DOC18/42404
SSD 8614

**Exhibition of SSD 8614 – Hurlstone Agricultural High School (Hawkesbury), Richmond
Western Sydney University Campus, 2 College Street, Richmond**

Attachment 1 – OEH comments on SSD 8614 – Hurlstone Agricultural High School (Hawkesbury), Richmond Western Sydney University Campus, 2 College Street, Richmond

Figure 7 – Pre Development Indicative Depths of Inundation & 1% AEP Flood Contours

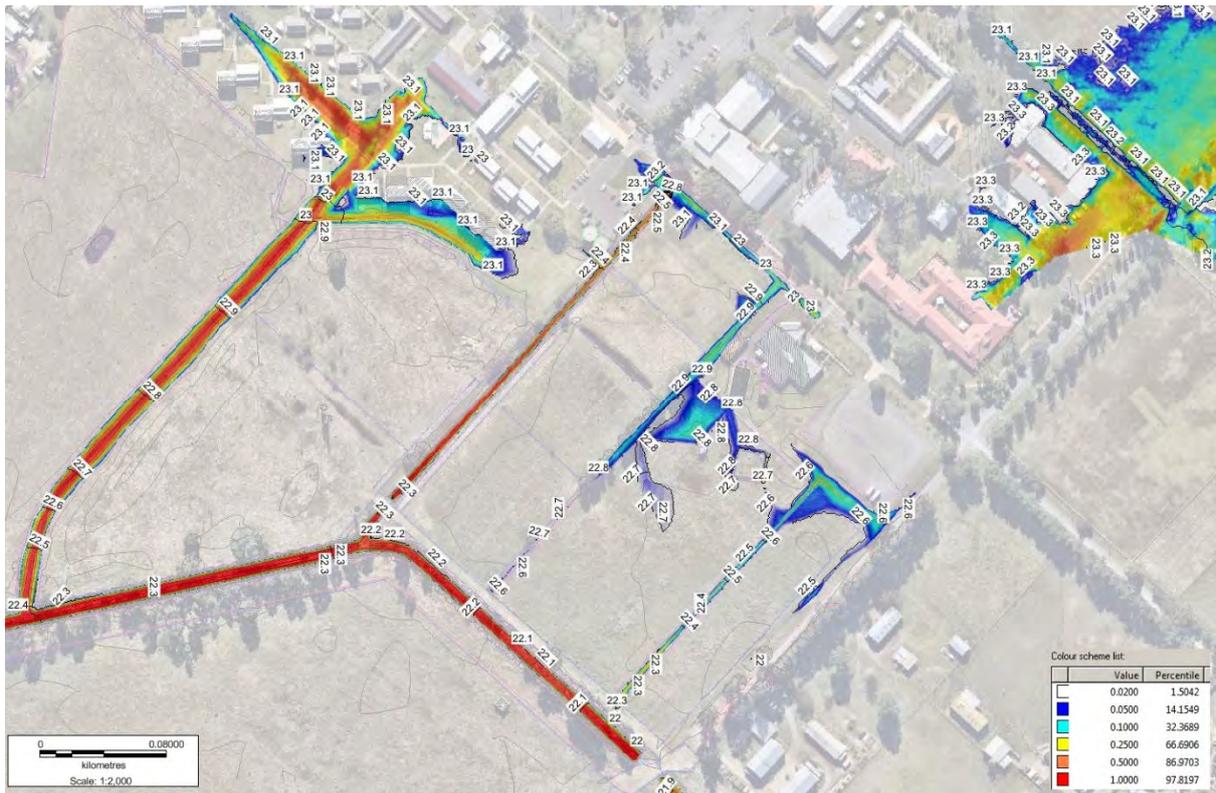
- Figure 7 (Pre-development) does not show the existing pipe from the university as shown in Figure 6. Clarification is sought on whether the pipe was modelled in the pre-development case. As the pipe is existing it should be included in the pre-development case.

Figure 9 - Post vs Pre Development Afflux Comparison

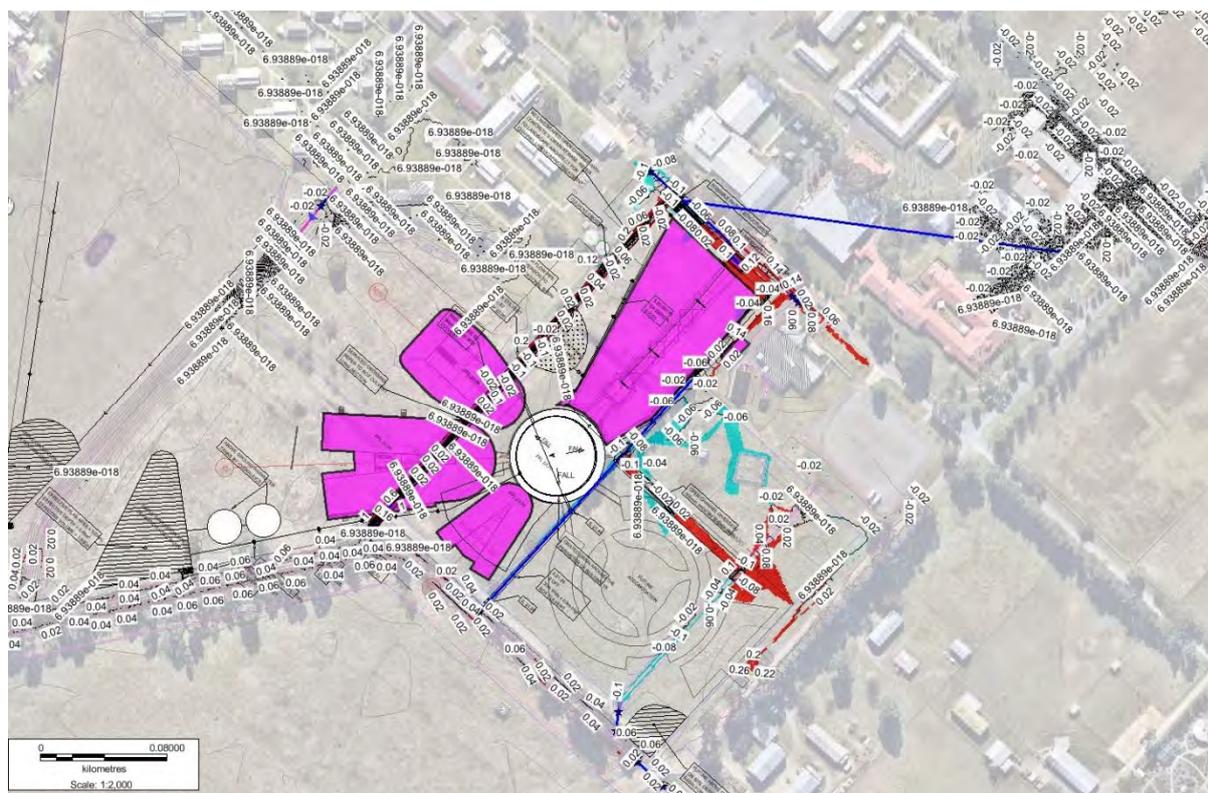
- The afflux map presented in Figure 9 is confusing to read. A legend should be on the figure as well as a simplification of how the afflux is presented. The text boxes with impact are confusing as to the exact location and the extent of the flood is hidden by these text boxes as well.
